File reference	TR040011
Status	Final
Author	The Planning Inspectorate
Date	25 June 2019
Meeting with	North Somerset Council and Womble Bond Dickinson (The Applicant)
Venue	WBD Office
Meeting objectives	Draft documents and submission
Circulation	All attendees

The Portishead Branch Line (MetroWest Phase 1) Order

Section 51 Advice – draft Application Documents provided by North Somerset District Council for The Planning Inspectorate’s (The Inspectorate’s) review

Checked By : Clare Williams Date: 14/11/2019

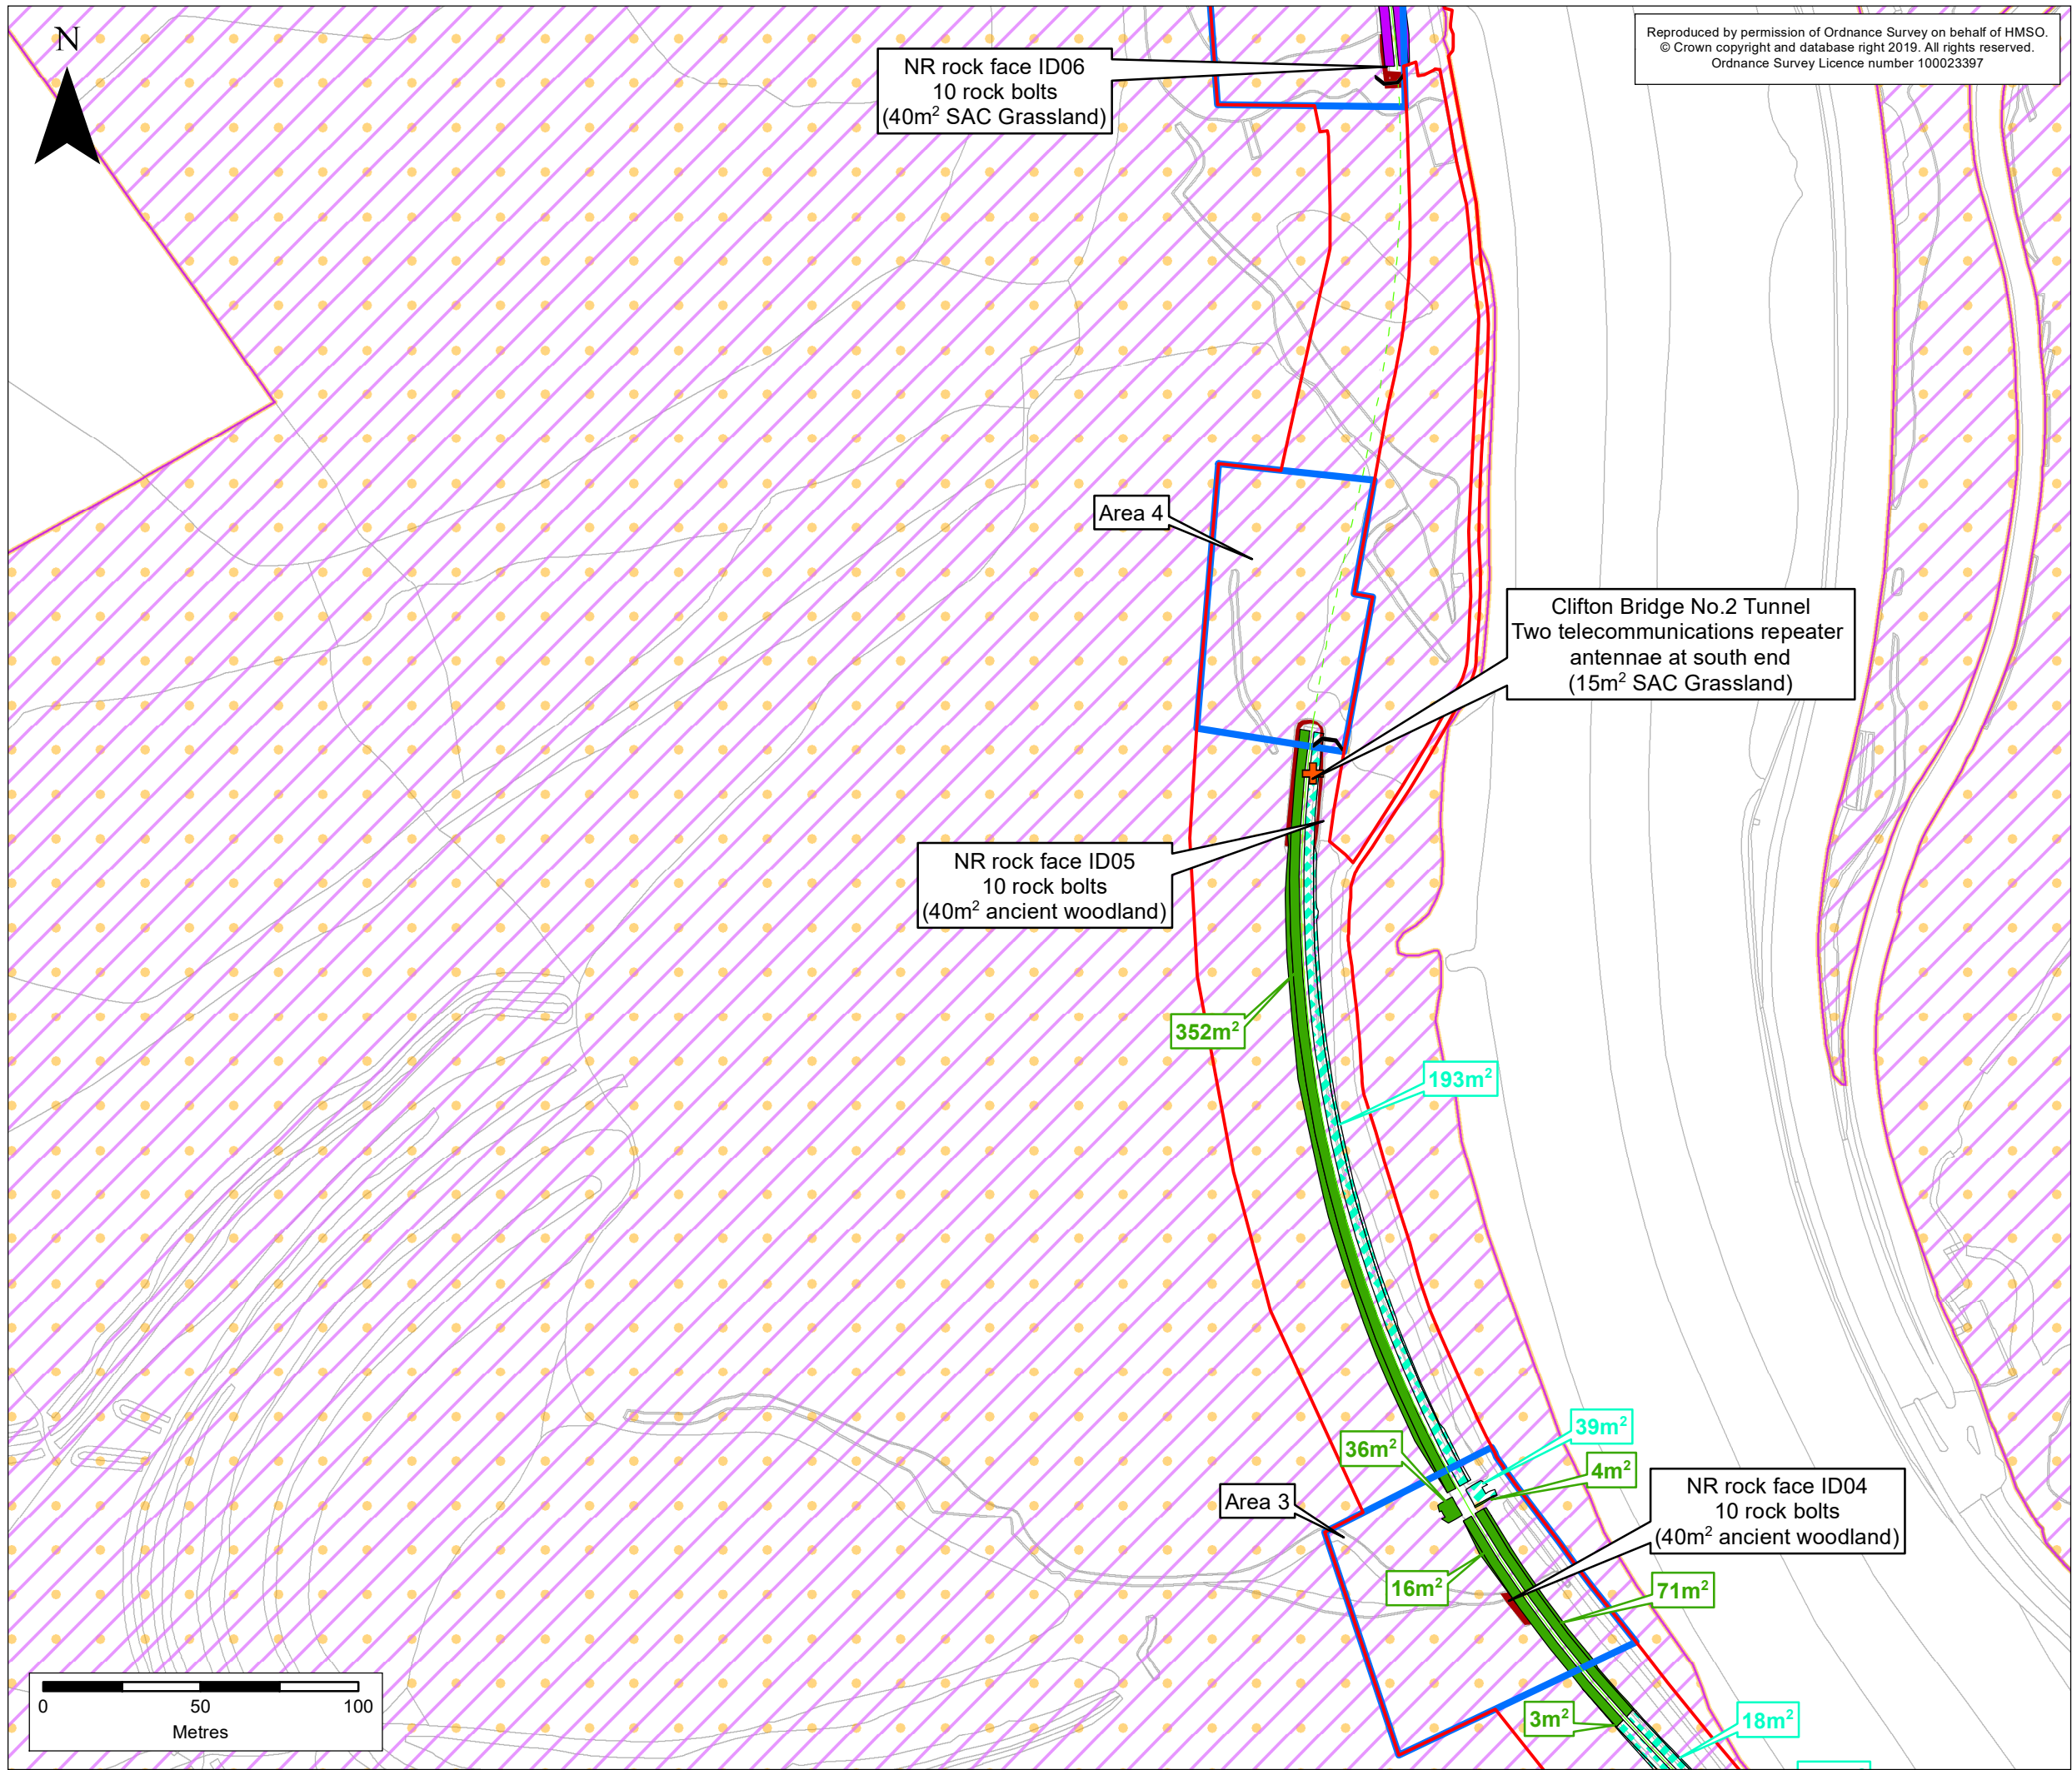
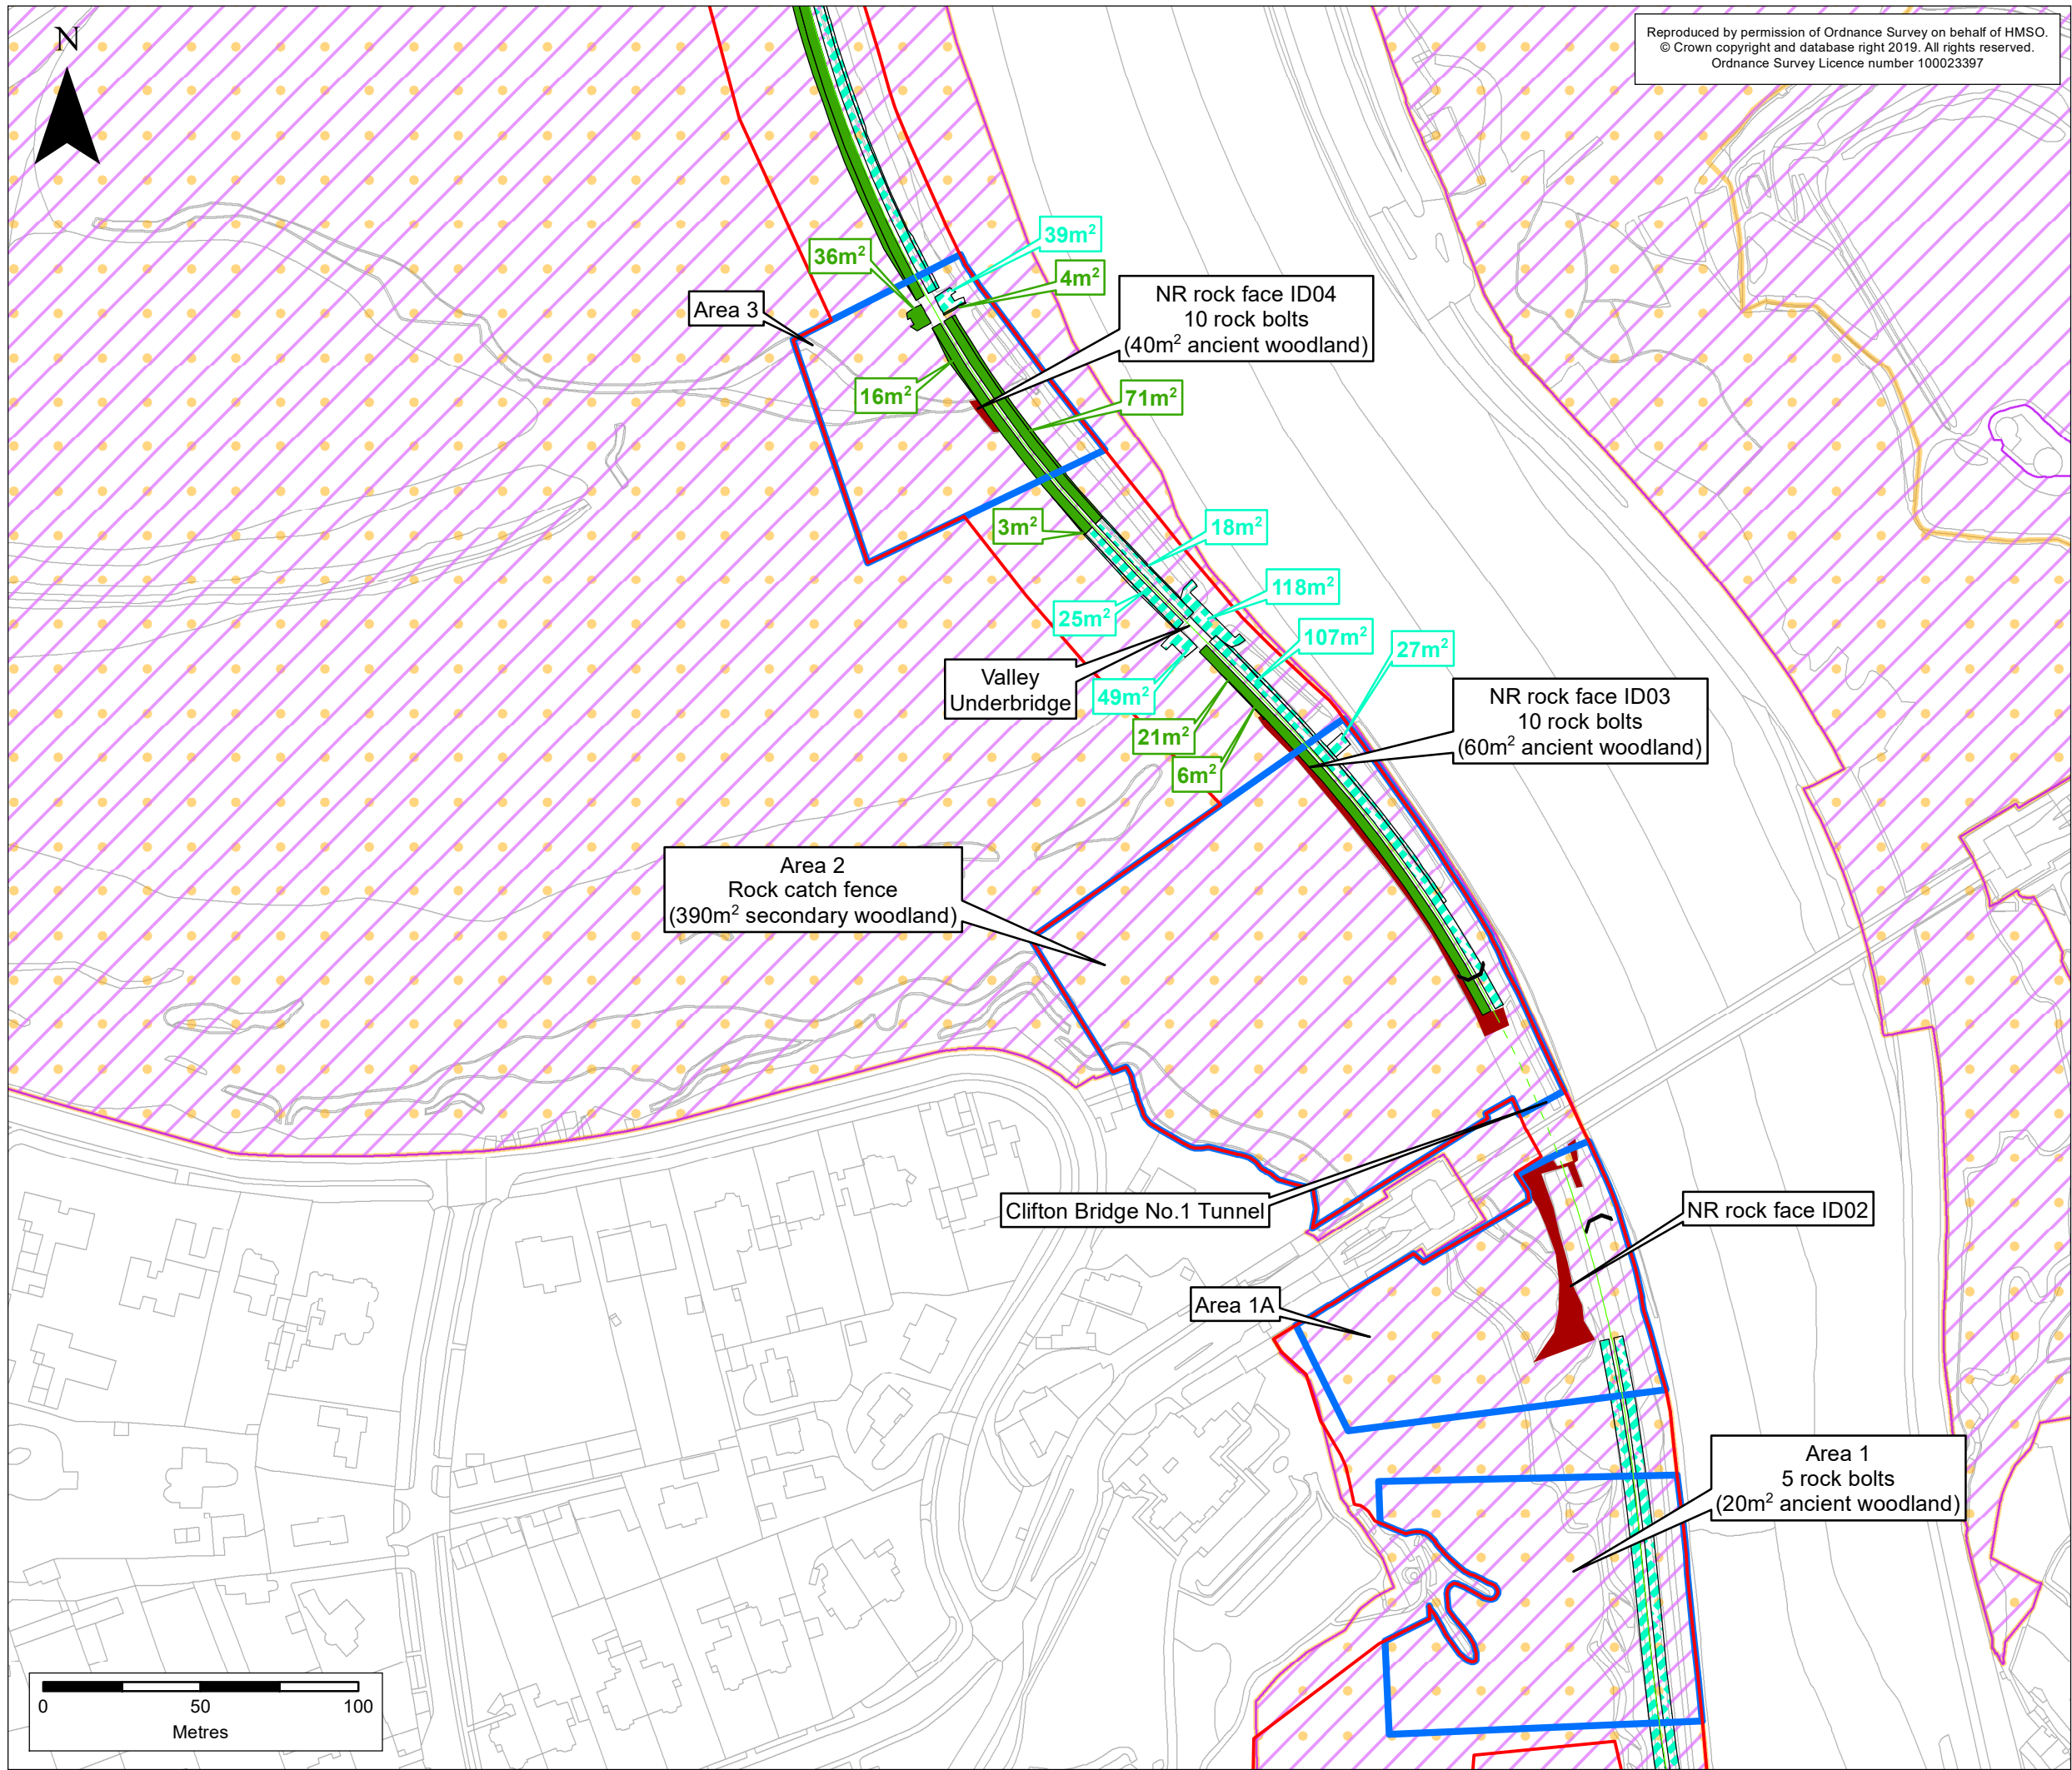
3.	Executive summary, 4.2.3	Areas of habitat loss	The text would benefit from stating %loss figures as well as actual hectarage loss. It is unclear whether the HRA includes the area of habitat loss on the cliff face within the total. This should be included.

14.	Table 5.1	BCC - definition of extent of vegetation removal and definition of limit of the works.	The HRA describes the extent of vegetation removal but it would help to illustrate the extent of this removal on a plan.
